Date: 12-Feb-2025  
Our Ref: 2024/93526

**Application for Approval of Details Reserved by Condition  
Town and Country Planning Act 1990  
Planning (Listed Buildings and Conservation Areas) Act 1990**

**Discharge of details reserved by conditions 3 (facing materials), 7 (floor levels), 9 (walls and fences), 10 (risk assessment), 15 (land stability), 16 (noise), 18 (renewable energy) on previous permission 2023/90582 for erection of 2 detached dwellings adj, 18B, Cowlersley Lane, Cowlersley, Huddersfield, HD4 5TY  
Application Number: 2024/93526**

Surveyed by JA	Drawn by JA	Approved by
Drawing No. 0724-ROG-11076	Date 18-07-2024	Revision
Scale 1:200@ A1		Sheet No. 1 of 1

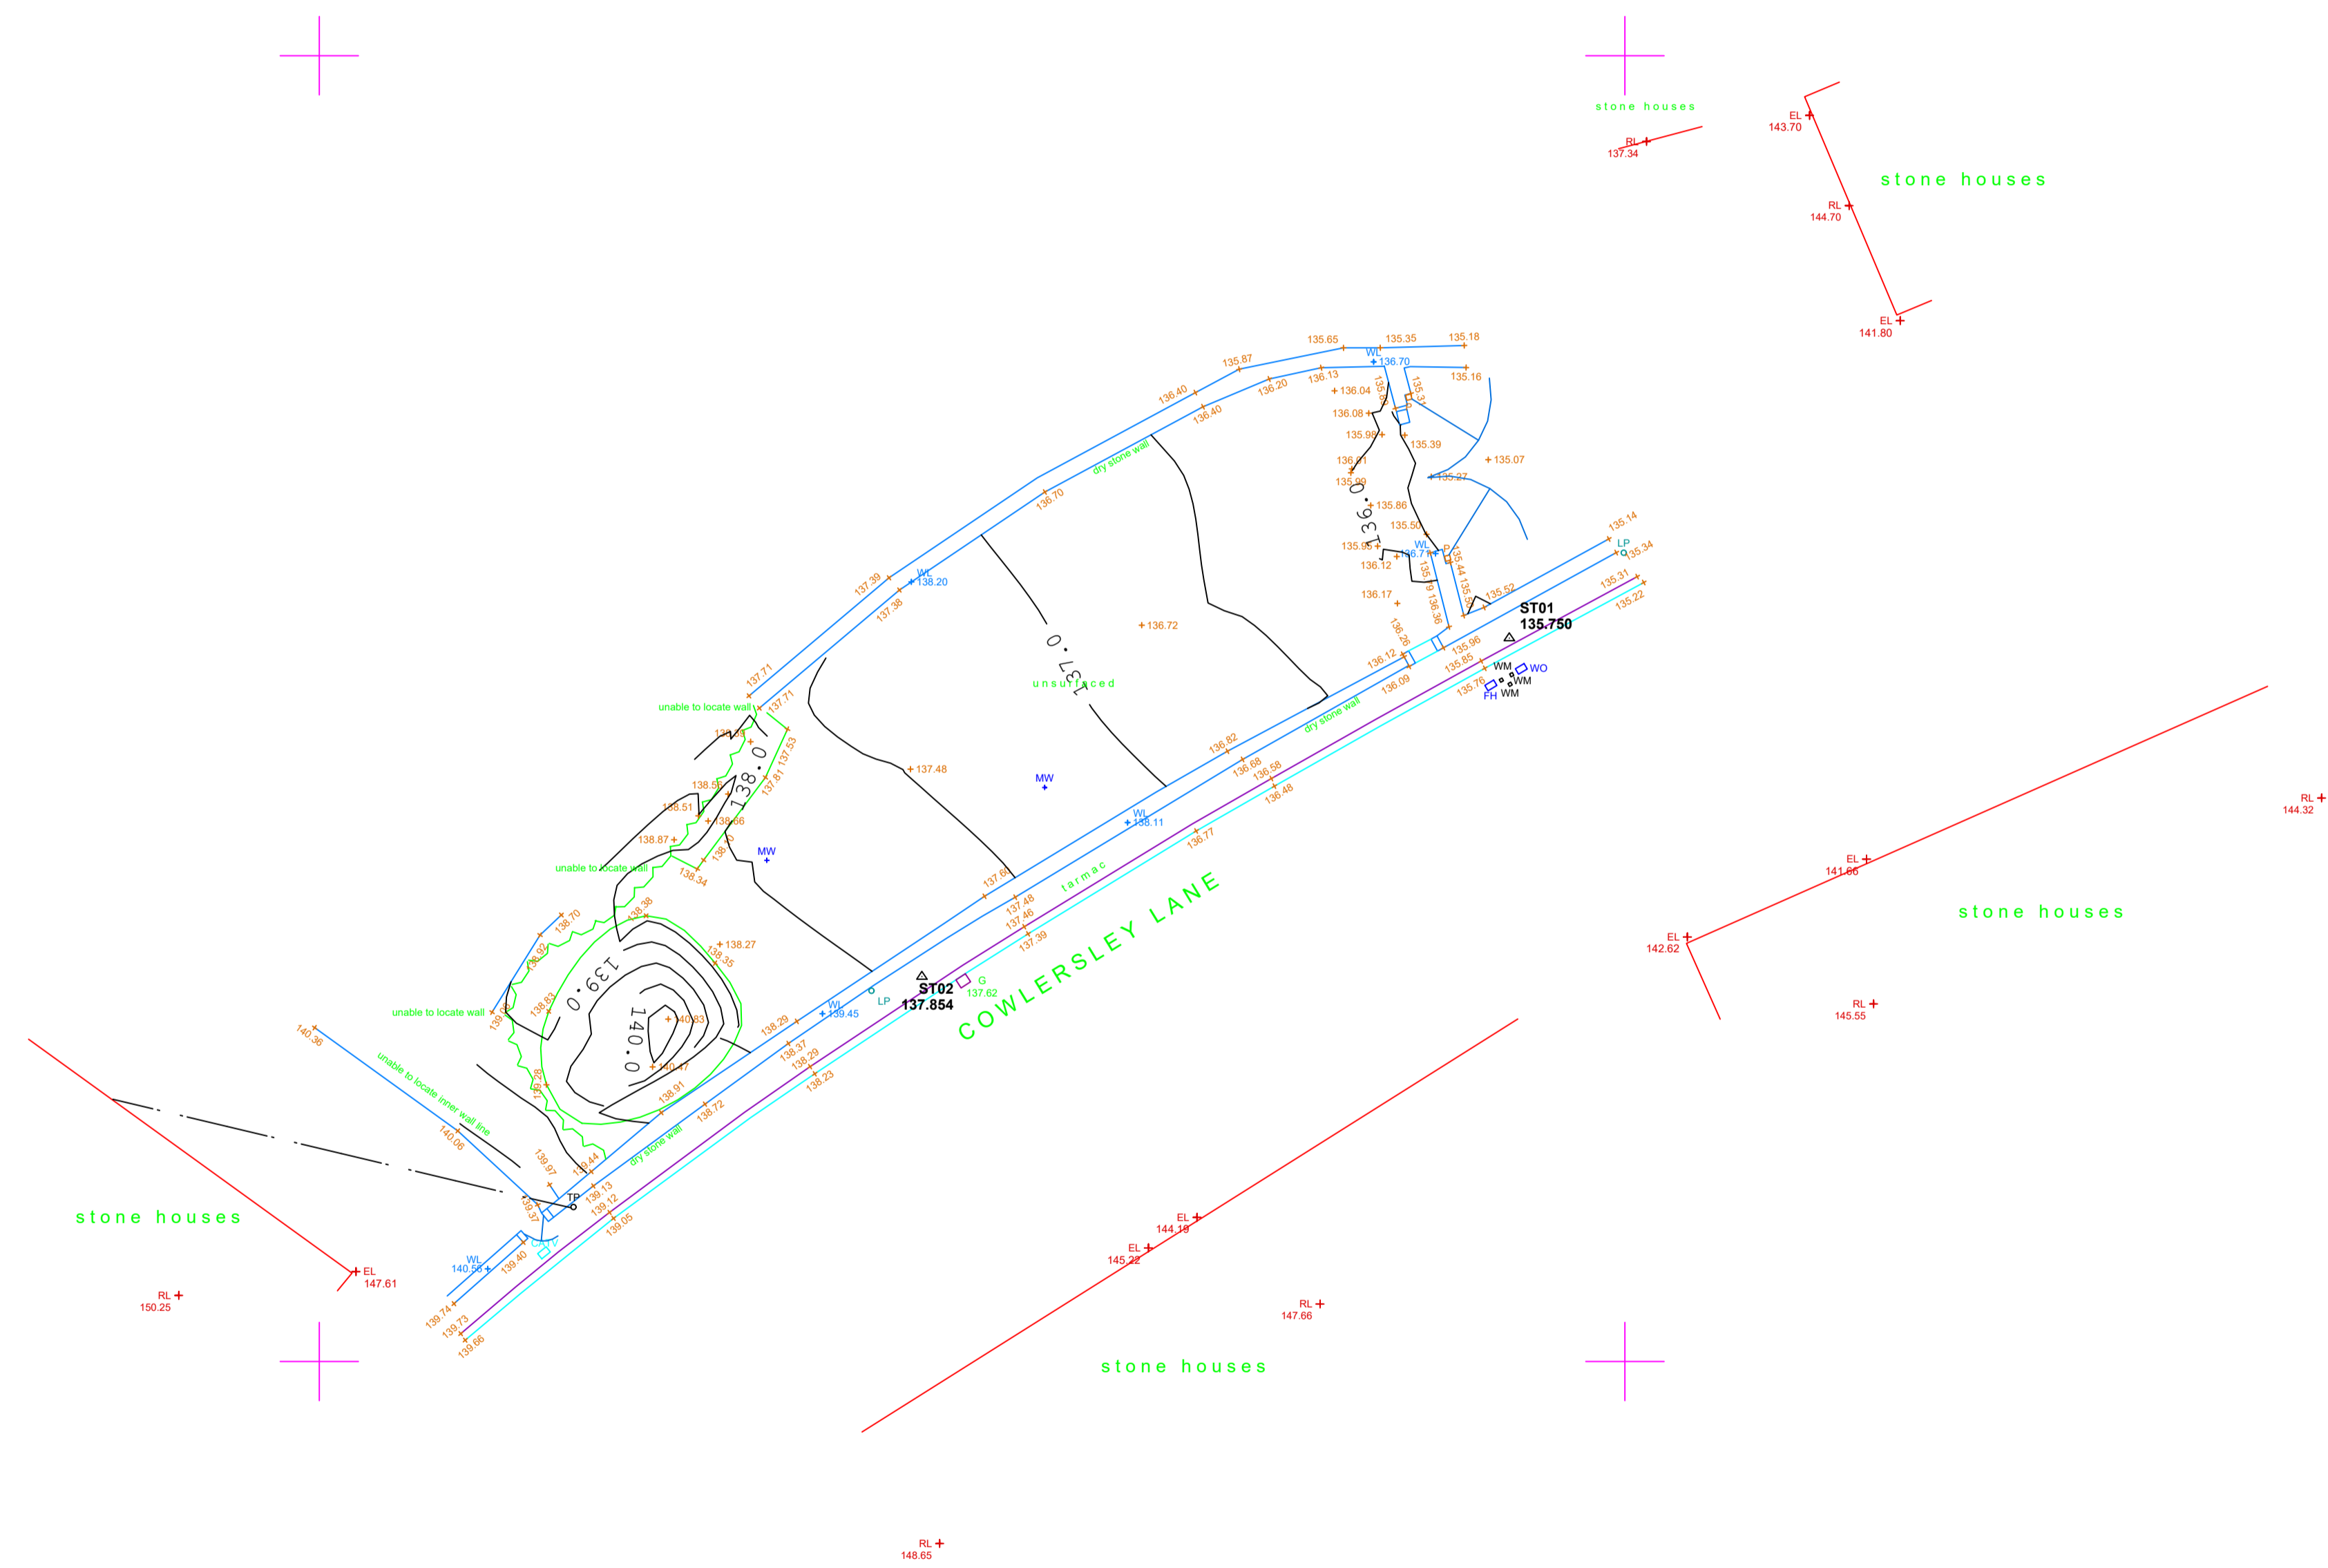
It is considered that, the plans show the existing site levels but not the proposed with the dwellings in situ; therefore, the plan do not satisfy the full requirement of condition 7 and it cannot be discharged.
